**From:** Paul Cann  
**Sent:** 02 January 2018 14:51  
**To:** Planning.Responses  
**Subject:** RE: Planning Consultation on: Y/92/17/OUT

*Engineers comments in respect to surface water drainage:*

**APPLICATION** Y/92/17/OUT

**Description of Works:** Outline application with all matters reserved save access, for up to 300 dwellings, link road, surface drainage, open space and landscaping. Departure from the Development Plan and Access route is within the Yapton (Main Road) Conservation Area.

FIGURE 40. Plan showing Sustainable Urban Drainage Strategy for the site

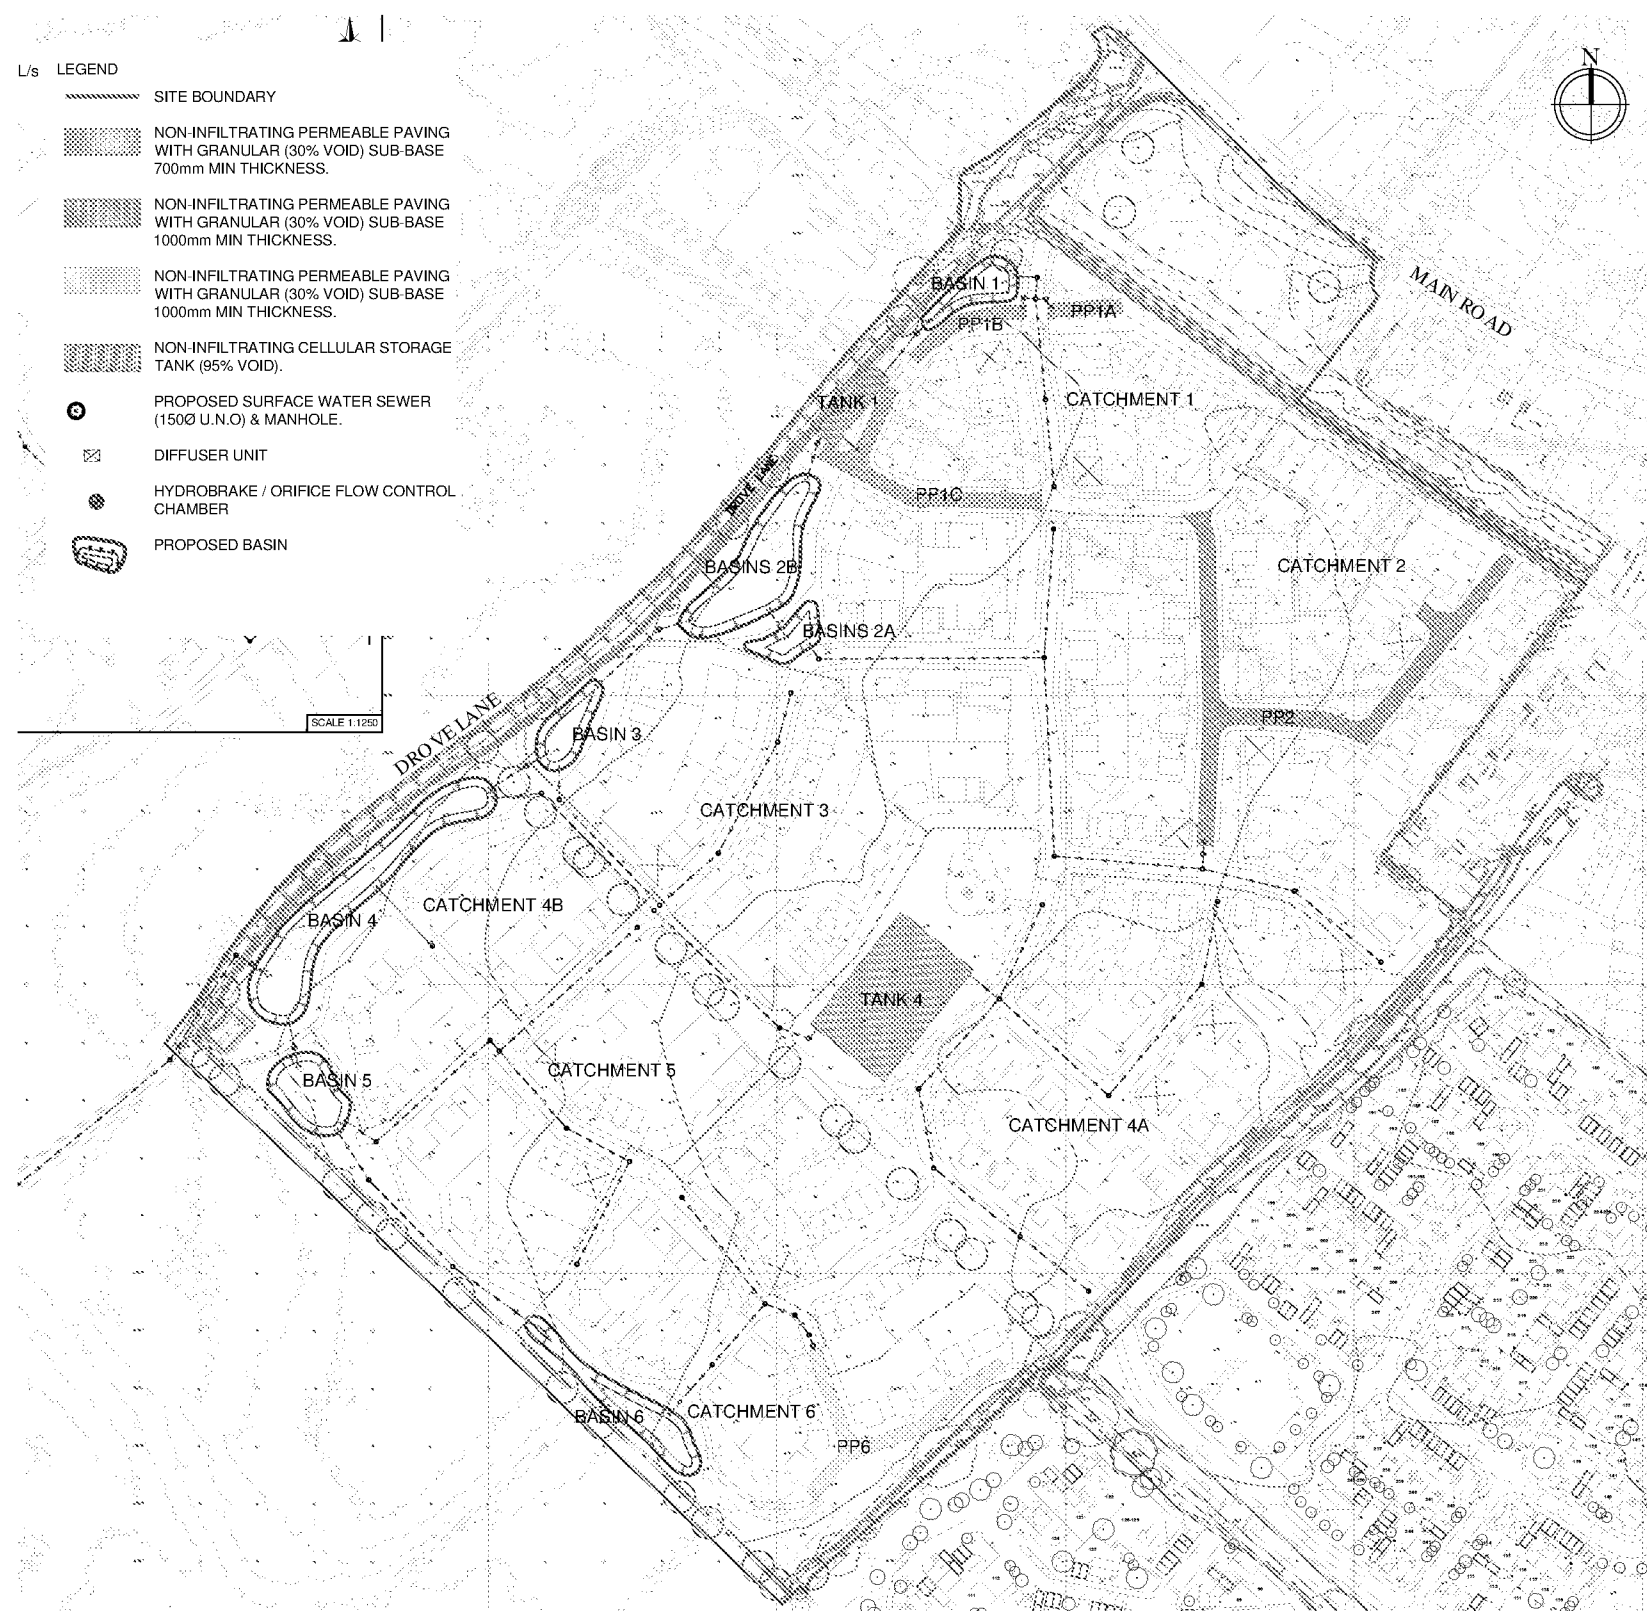
Soakaways/infiltration must be investigated for surface water disposal. Whilst the applicant has carried out some investigation into soakage potential (Sept/Oct 2017), whereby infiltration was found to be possible, they have not incorporated this into the initial surface water drainage design. The soakage potential will need to be further verified by winter groundwater monitoring and percolation testing at agreed depths. Should infiltration not offer a full solution, then a hybrid scheme (infiltration/restricted discharge to watercourses) is likely to be required.

Infiltration rates for soakage structures are to be based on percolation tests undertaken in the winter period and at the location and depth of the proposed structures. The percolation tests must be carried out in accordance with BRE 365, CIRIA R156 or a similar approved method and cater for the 1 in 10 year storm between the invert of the entry pipe to the soakaway, and the base of the structure. It must also have provision to ensure that there is capacity in the system to contain below ground level the 1 in 100 year event plus 40% on stored volumes, as an allowance for climate change. Adequate freeboard must be provided between the base of the soakaway structure and the highest recorded annual groundwater level identified in that location.

Any SuDS or soakaway design must include adequate groundwater monitoring data to determine the highest winter groundwater table in support of the design. The applicant is advised to discuss the extent of groundwater monitoring with the Council's Engineers. Supplementary guidance notes are also enclosed for information.
